PRELIMINARY FLOOR PLANS

FINAL FLOOR PLANS TO BE SUBMITTED AT LATER DATE

FIRST FLOOR- TO SCALE (1/16")

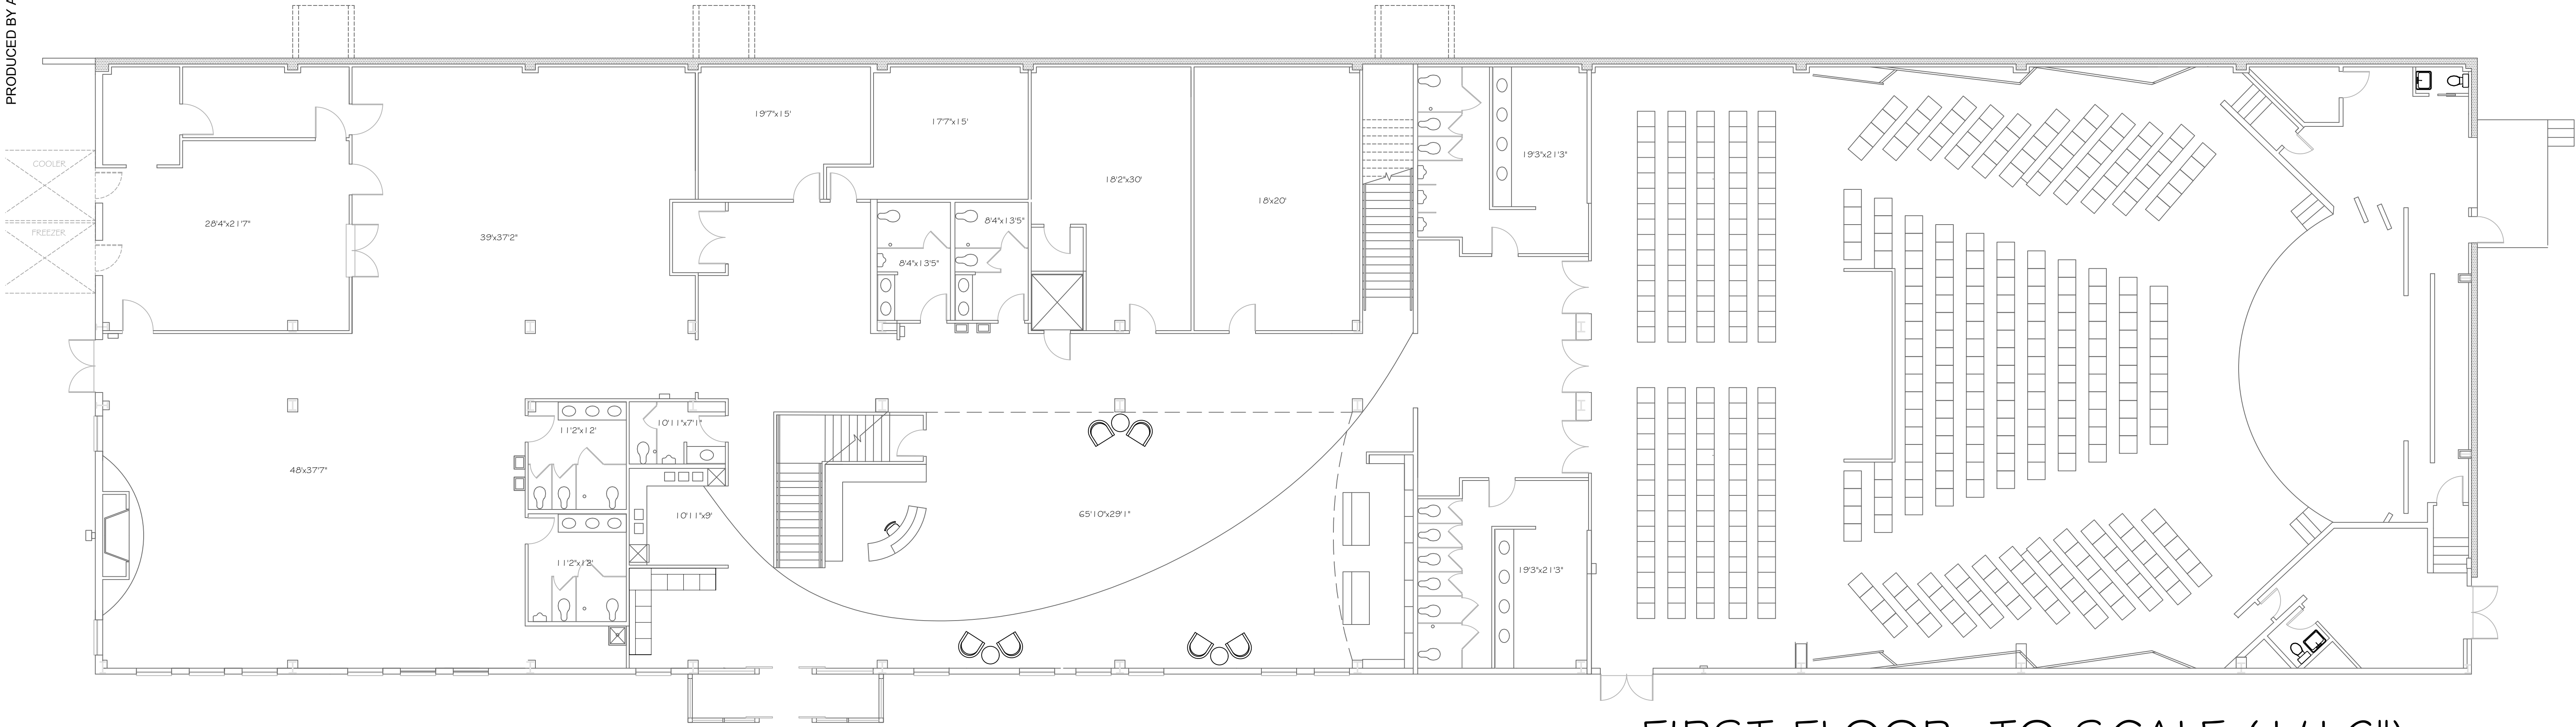
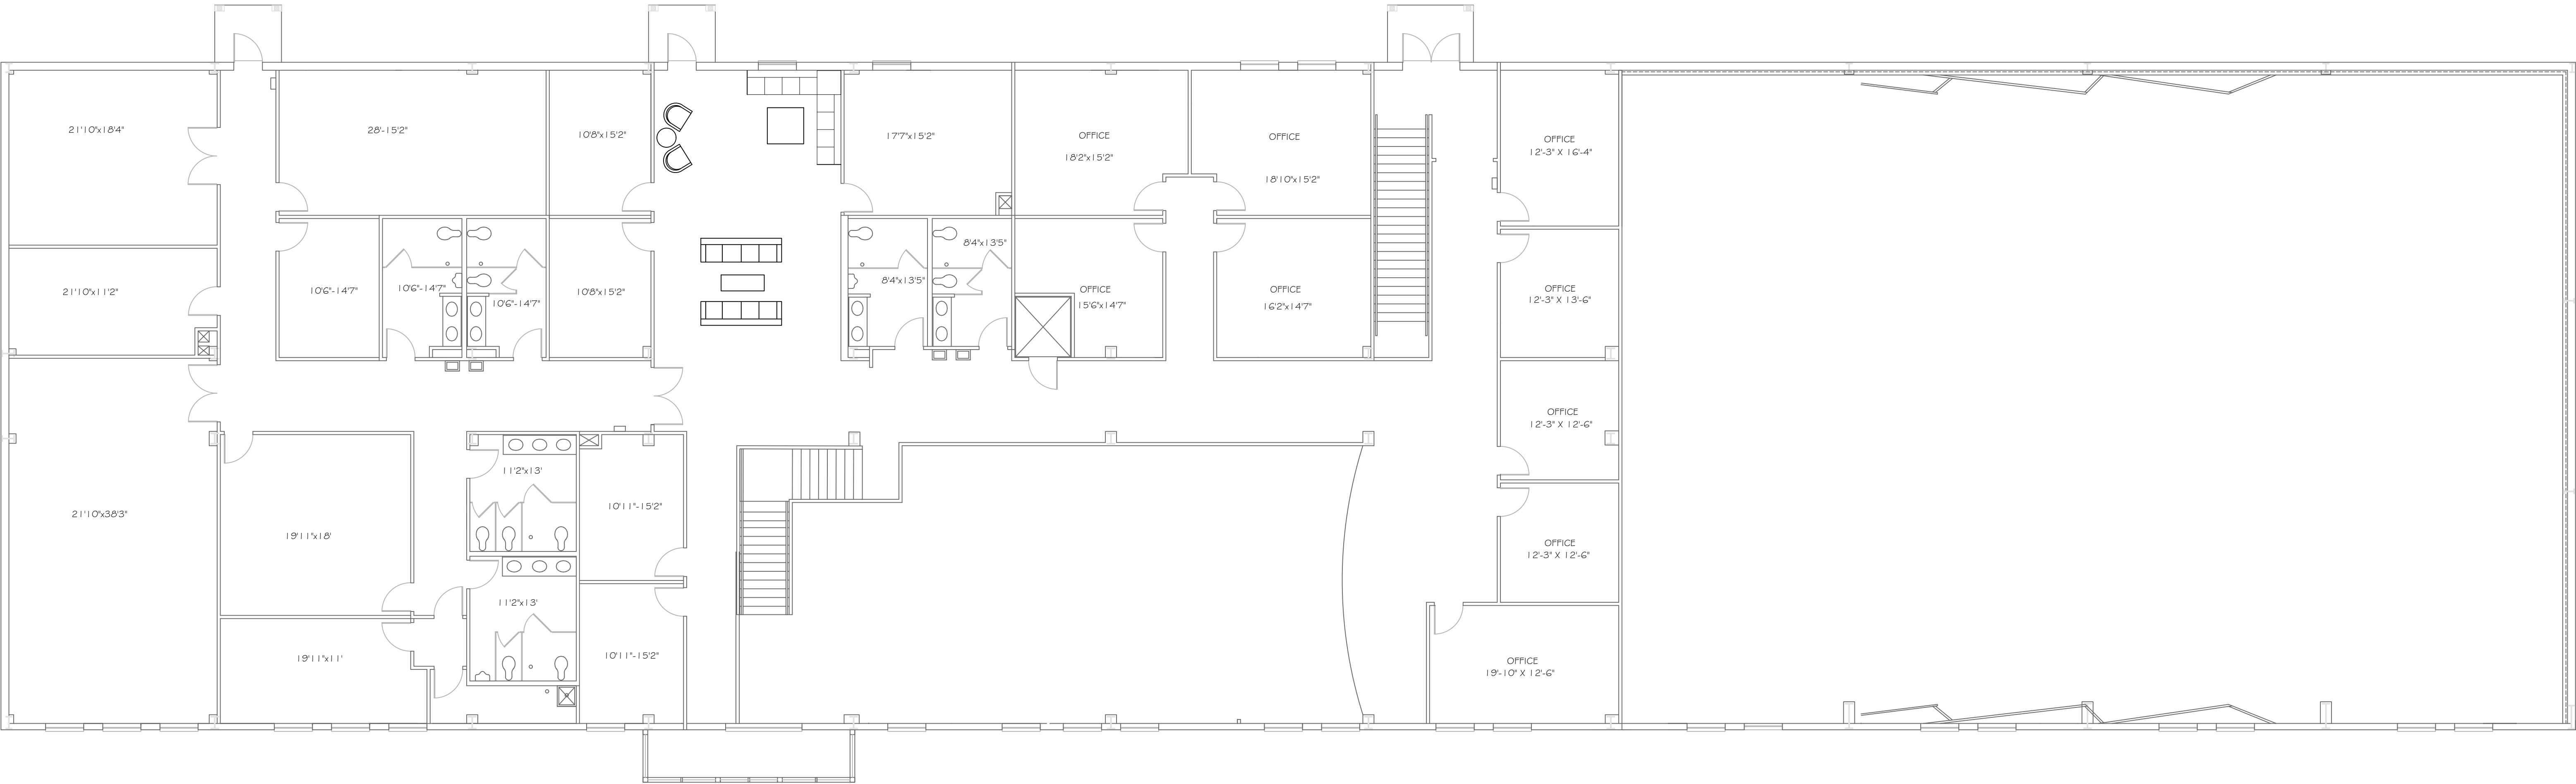
Please label the uses of the various rooms in the building.

Also list the number of seats in the sanctuary including those utilized by the ministry.
